Rezoning Transportation Analysis

Petition Number: 2020-197

Revision Log:	Date	Description
	12-28-2020	First Review (KP)
	01-21-2021	Second Review (KP)

RZ-1.0

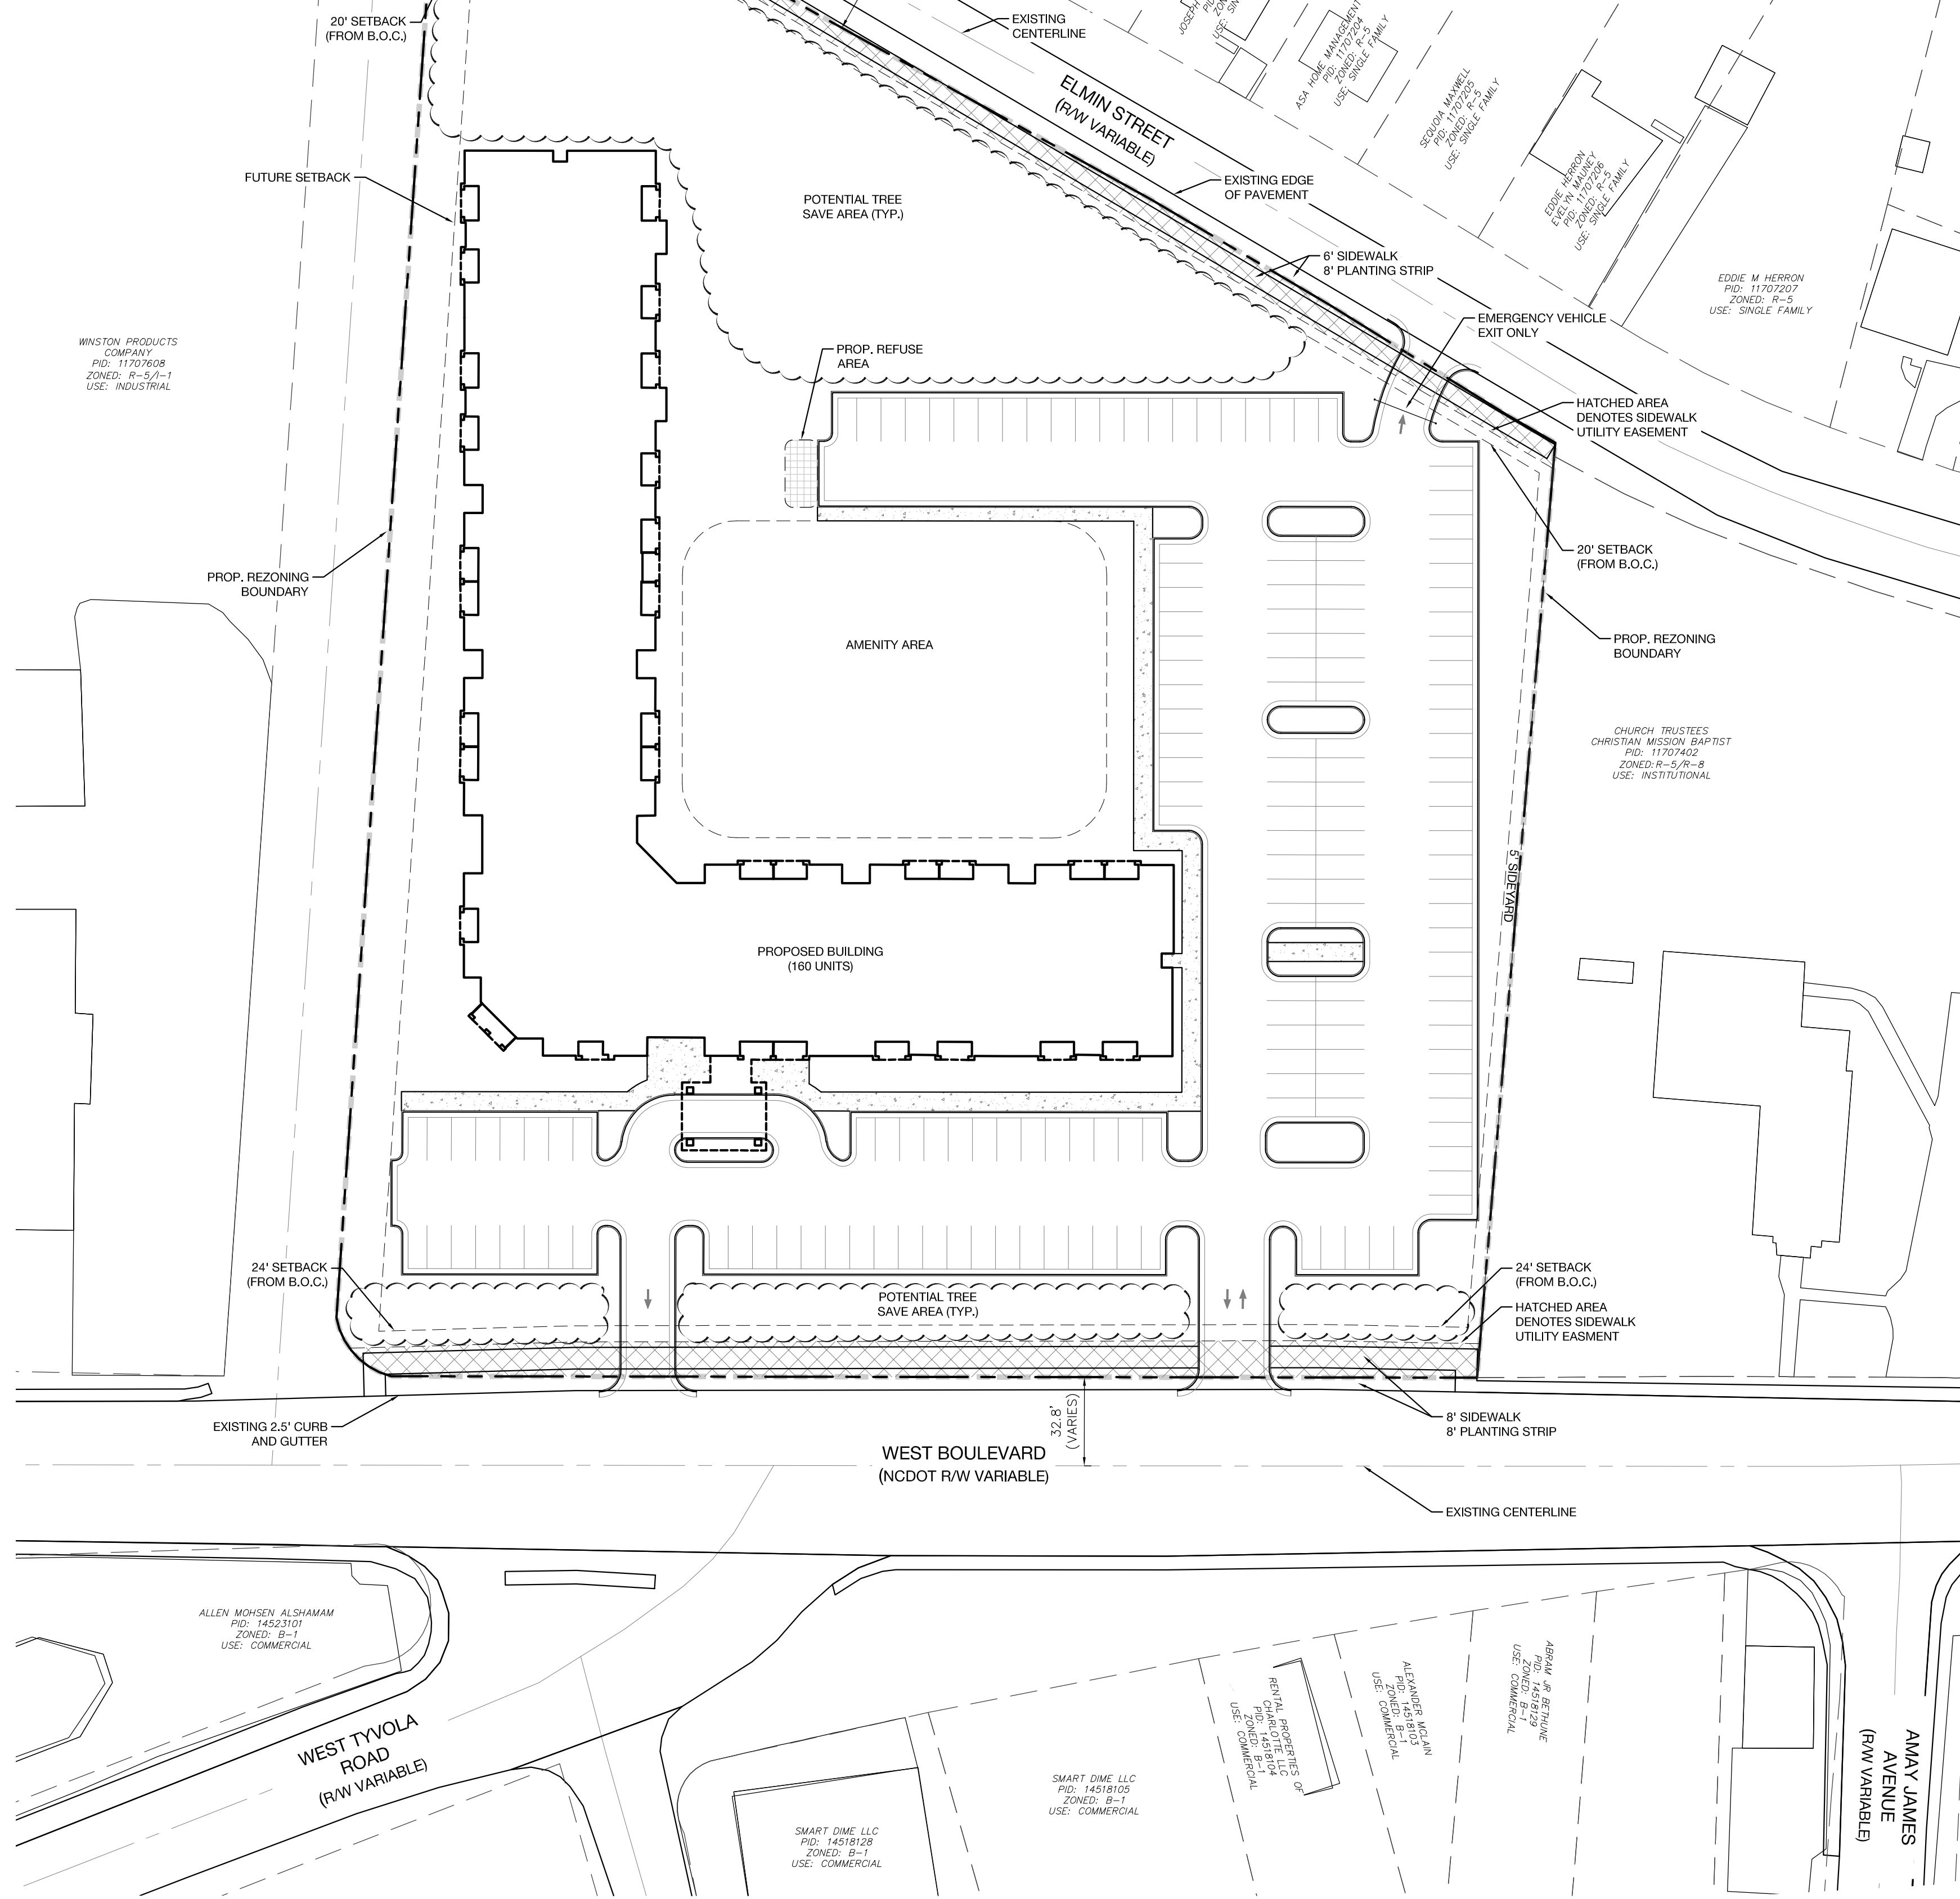
5. Revise site plan by clearly labeling and dimensioning the paper right-of-way immediately to the west of the site.

6. Revise the site plan by including the existing infrastructure and striping for the center median and turn lane on West Boulevard and the channelized island at West Tyvola and West Boulevard.

7. Revise the site plan by creating a full movement (ingress and egress) driveway onto/from Elmin Street.

9. Revise site plan and conditional notes by removing the proposed driveways on West Boulevard and developing a portion of the existing paper right-of-way to provide access into the site. Additionally, the driveway at the paper right-of-way and West Boulevard will be a right-in right-out movement which will necessitate the extension of the existing center-lane median on West Boulevard, in accordance with NCDOT Standards. Lastly, the portion of developed paper right-of-way will be developed to the City's Local Residential Medium Section (U-02) and will include an 8-foot planting strip and 6-foot sidewalk along the east side (the site's frontage) of the developed paper right-of-way. This will also include a dead-end street barricade and marker in-line with CLDSM, at the street stub. The site plan should label and dimension each item from the road centerline.

11. The site is located on a block length of 2,619 feet (see below blue line), from Old Steele Creek Road to Elmin Street. The proposed site's paper street is located approximately 1330 feet to the west of intersection of Old Steele Creek Road and West Boulevard. Since the UR-2 zoning district is being requested under this petition, please address Outstanding Issues 5 and 9, to promote walkability and connectivity, per the Urban Street Design Guidelines.

- 15. **New comment as a result of the 01-12-2021 Site Plan resubmittal:** Revise the site plan and conditional notes by including an 8-foot dimension on the sidewalk constructed in the paper ROW. Additionally, locate the back of the 8-foot sidewalk 29-feet from the centerline of the paper ROW, in accordance to the City's Local Residential Medium Section. Additionally, place a sidewalk utility easement 2-feet behind the back of sidewalk where feasible.

- 16. **New comment as a result of the 01-12-2021 Site Plan resubmittal:** Revise the site plan to extend the 8-foot sidewalk and planting strip, along West Boulevard, through the paper right-of-way and tie the sidewalk into the existing curb ramp on the west side of the paper right-of-way.

- 17. **New comment as a result of the 01-12-2021 Site Plan resubmittal:** Revise the site plan by adding a curb ramp, on the south side of Elmin Street, at the corner of Moreland Street and Elmin Street. Additionally, revise the site plan by committing to bringing the existing curb ramp on the north side of Elmin Street to CLDSM standards.

18. **New comment as a result of the 01-12-2021 Site Plan resubmittal:** Revise the site plan to extend the 8-foot sidewalk and planting strip, along Elmin Street, to the west boundary of the paper right-of-way.

19. **New comment as a result of the 01-12-2021 Site Plan resubmittal:** Remove conditional note 3.E. No portion of this right-of-way will be abandoned.
